CITY OF ALBUQUERQUE

October 29, 2019

**Re: Townhouses For Buchanan
1106 Griegos Rd NW
Request for Certificate of Occupancy
Transportation Development Final Inspection
Engineer's/Architect's Stamp dated 10-30-18 (F14D058A)
Certification dated 10-23-19**

TRAFFIC CONTROL LAYOUT
Scale: 1" = 20'-0"

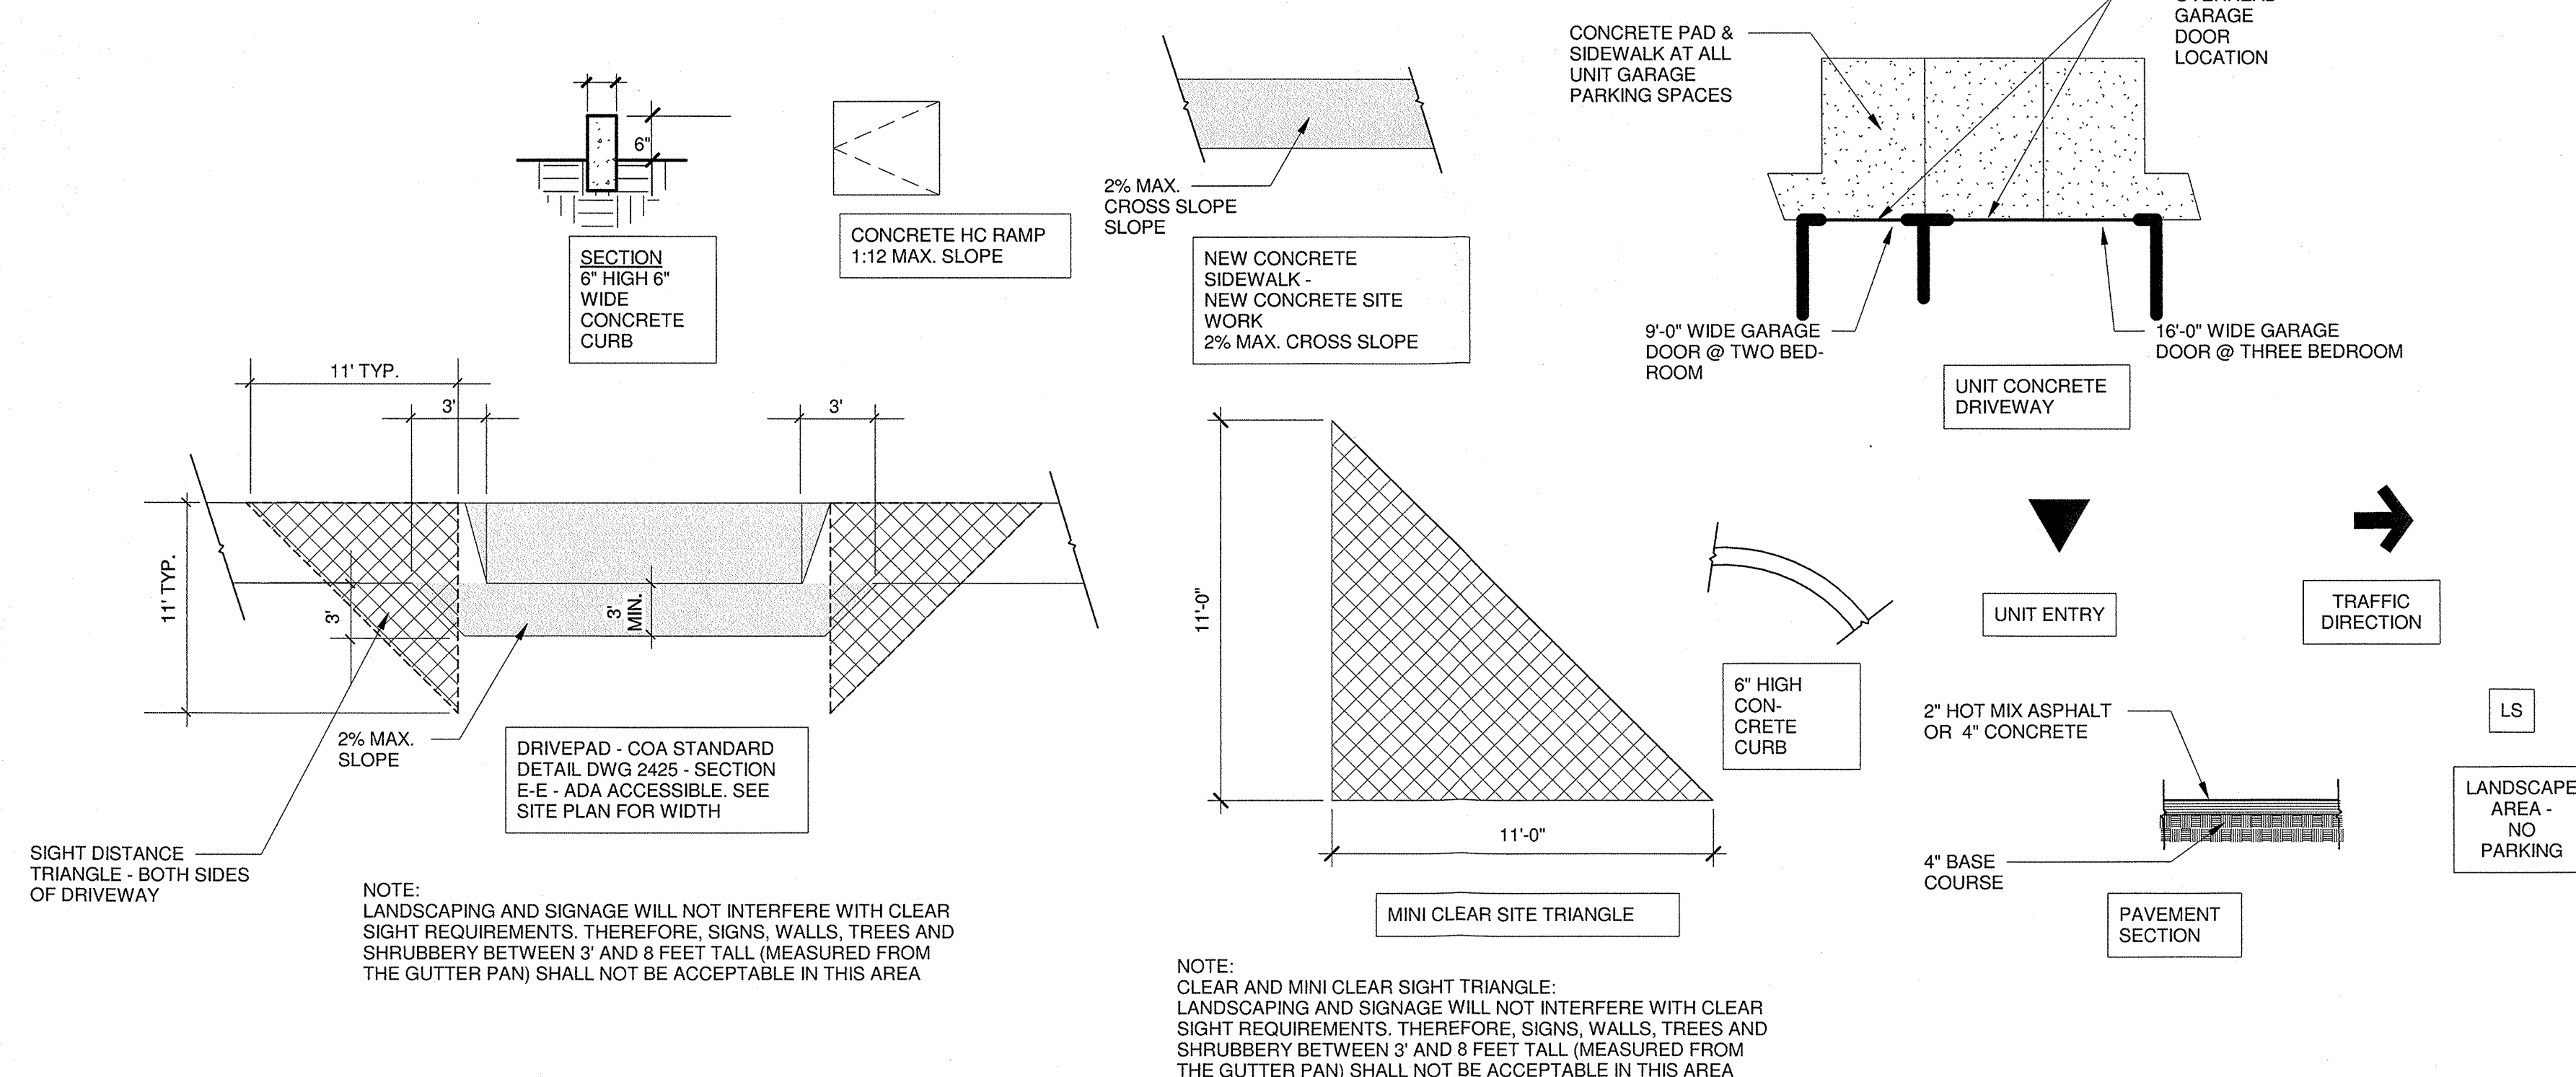
- Extend concrete curb (See attached photo and condition of approval)
- Remove security fence
